Application for a non-material amendment following a grant of planning permission.

Number	
Suffix	
Property name	Hazel Cottage
Address line 1	Church Lane
Address line 2	
Address line 3	
Town/city	Yapton
Postcode	BN18 0EH
Description of site location must be completed if postcode is not known:	
Easting (x)	497906
Northing (y)	103631

Single storey side extension linking semi-detached garage to existing house including conversion of existing garage to habitable use and rear extension. This application affects the setting of a listed building.	
Reference number:	Y/89/19/HH

Change proposed rooflight to a lantern light

PROJECT TITLE	Proposed Development at Hazel Cottage Church Lane Yapton Arundel			DRAWING TITLE	Proposed Elevations	No	REVISION	DATE
				STATUS	Non Material Amendment			
				SCALE	1:100 @ A3			
				DATE	30.10.2020			
				DRAWN BY	DE			
				DRAWING No	NM-302-06

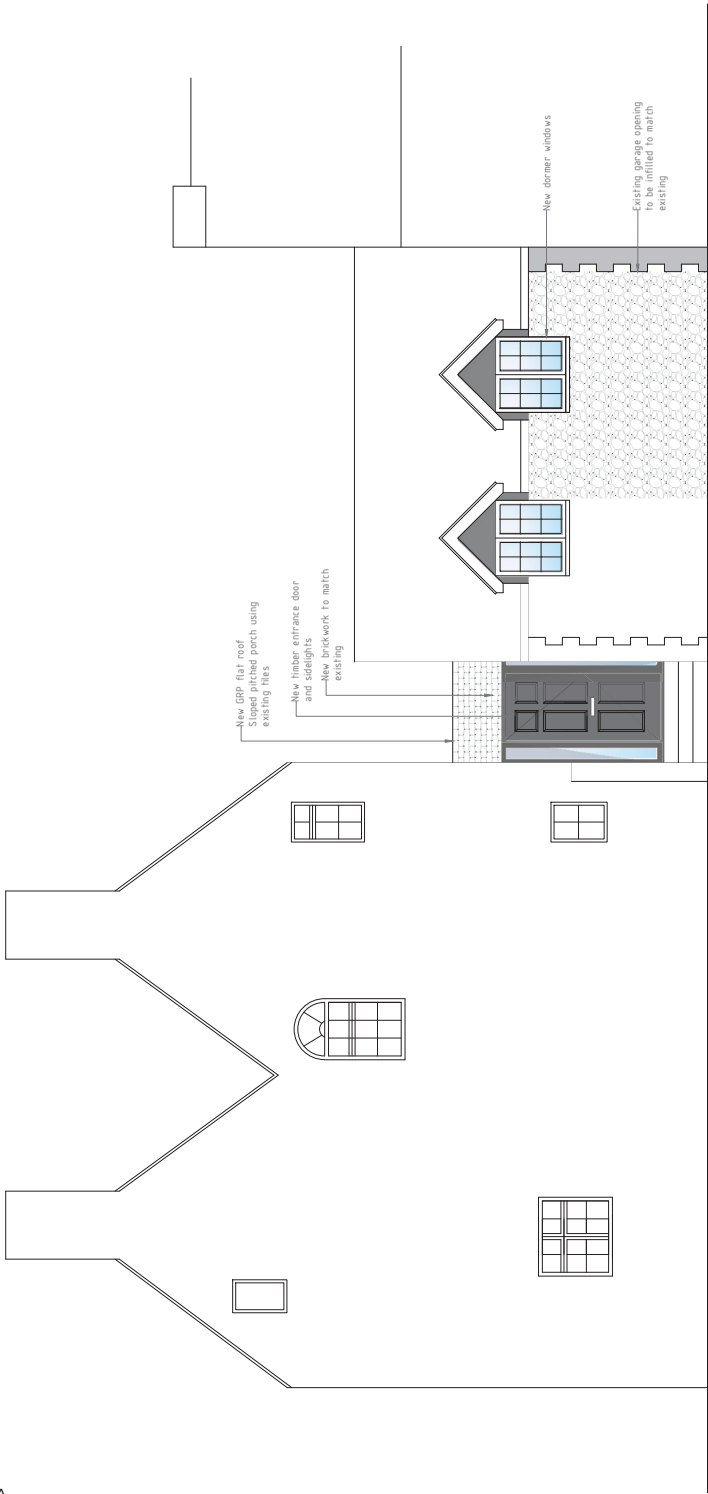
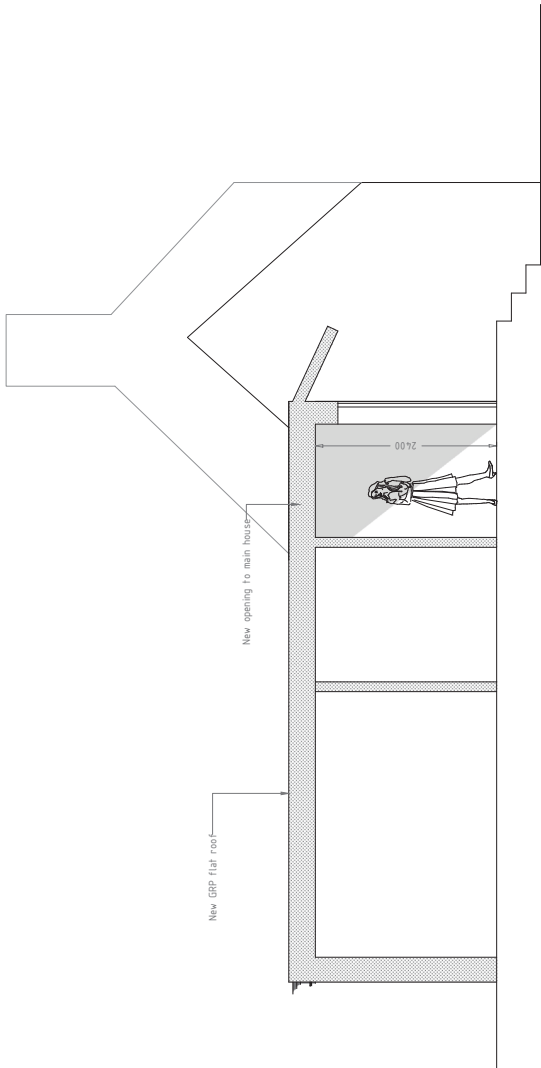
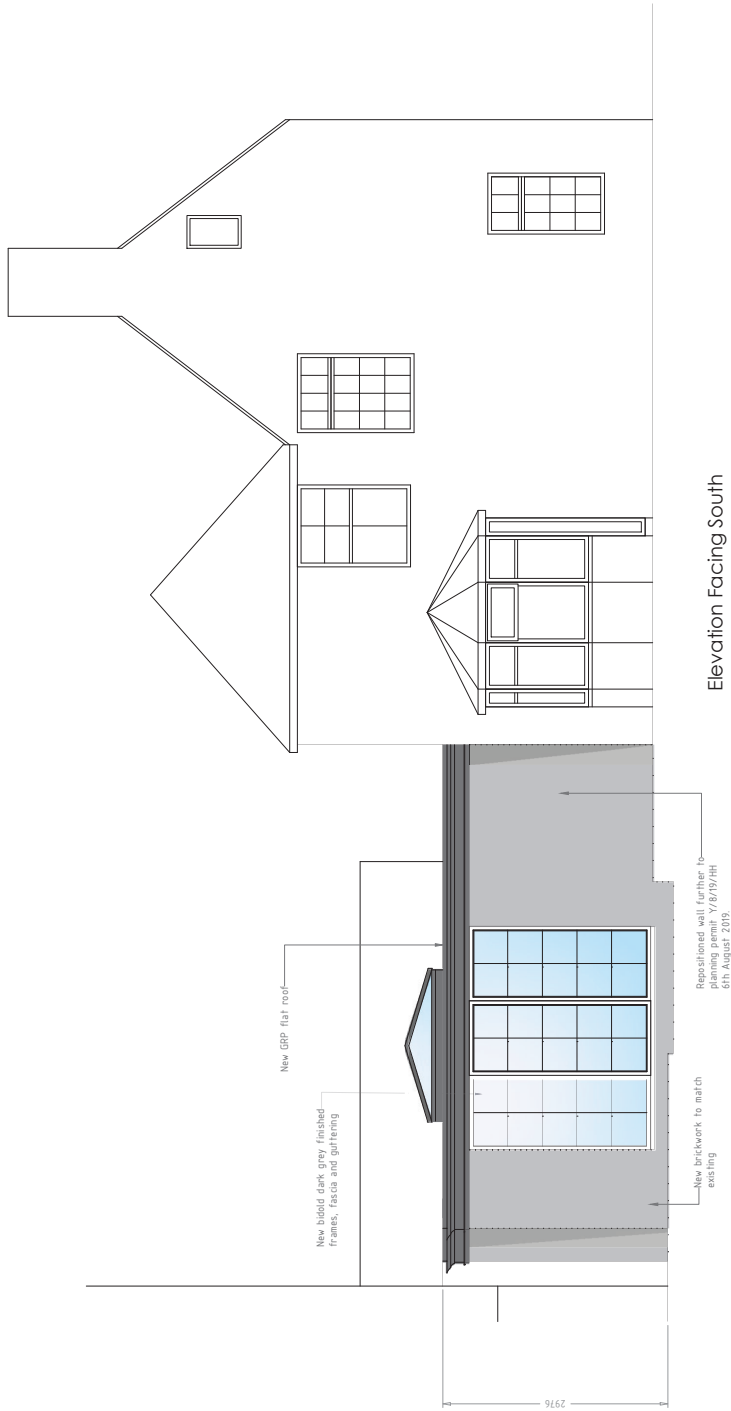
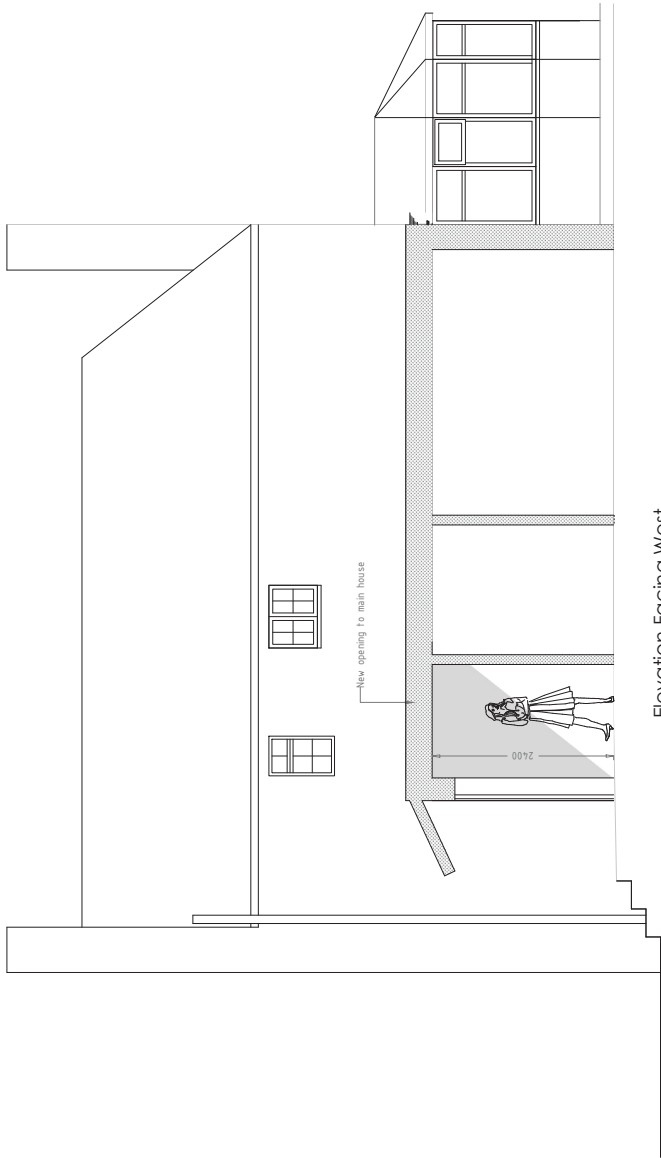
The proposed lantern would allow more light and would work better than the previous proposed rooflight.
